Your ref: 3/2026/0045

Location: 70 Mellor Brow Mellor BB2 7EX

Proposal: Proposed alterations to front boundary retaining wall including repointing, increase in height, new copings, steel railings along the top of wall and removal of existing hedge.

**Elevation from Roadway - Proposed**

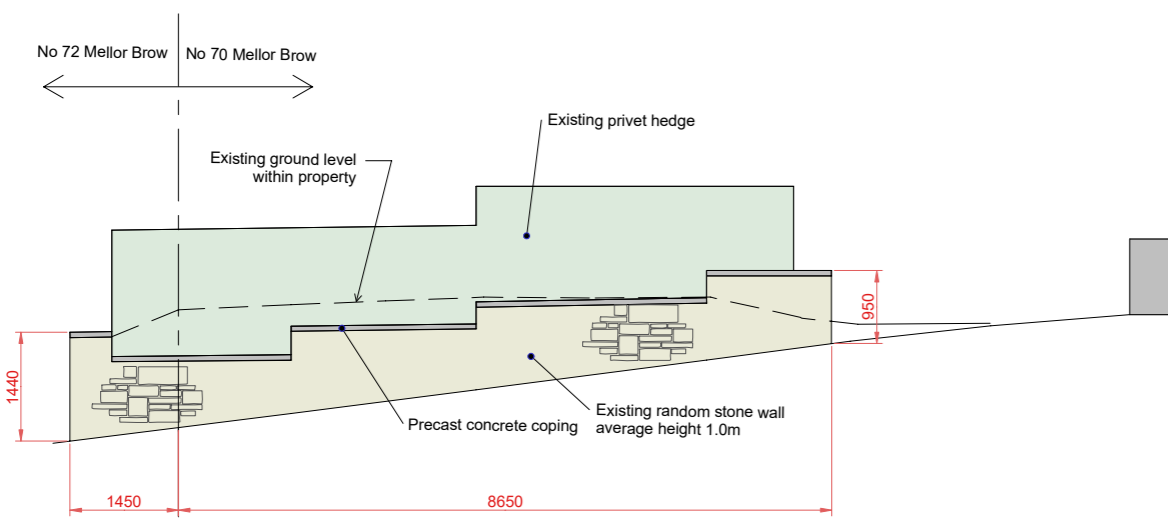
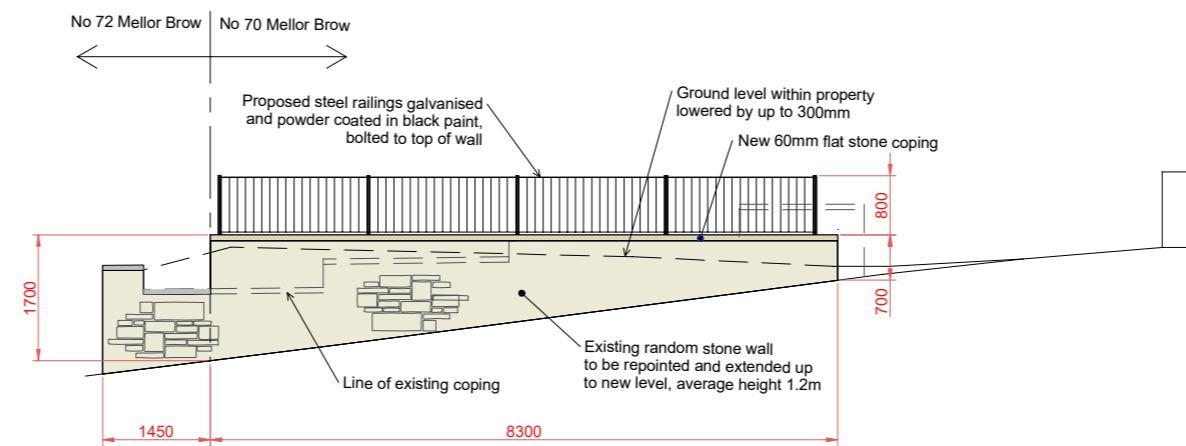
Whilst the proposal does not make a significant impact to the current visibility constraints, the LHA acknowledges that the removal of the vegetation which currently sits over boundary wall will assist in improving visibility which will be replaced with railings.

**Typical Cross-Section - Proposed**

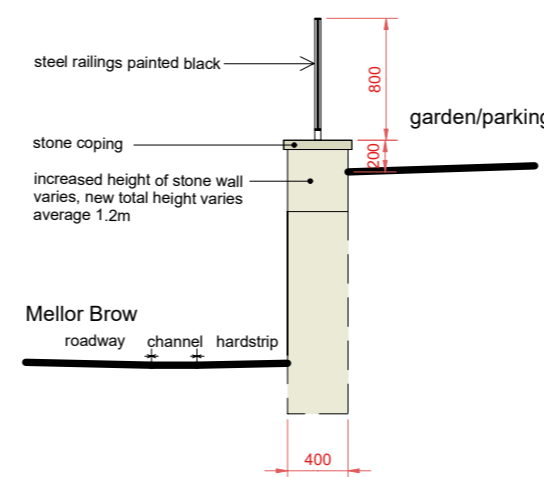
Amendments to the retaining wall fronting Mellor Brow will require the applicant to provide a structural report setting out how any structures will be assessed, excavated, constructed, strengthened or demolished to ensure the continued safety of the adjacent highway.

1. No development shall take place until an Approval In Principle (AiP) Structural Report setting out how any structures within 6 metres of the edge of the adopted highway (and outside of this measure where the failure of any structures would affect the safety of road users) will be assessed, excavated, constructed, strengthened or demolished has been submitted to and approved in writing by the Local Planning Authority.
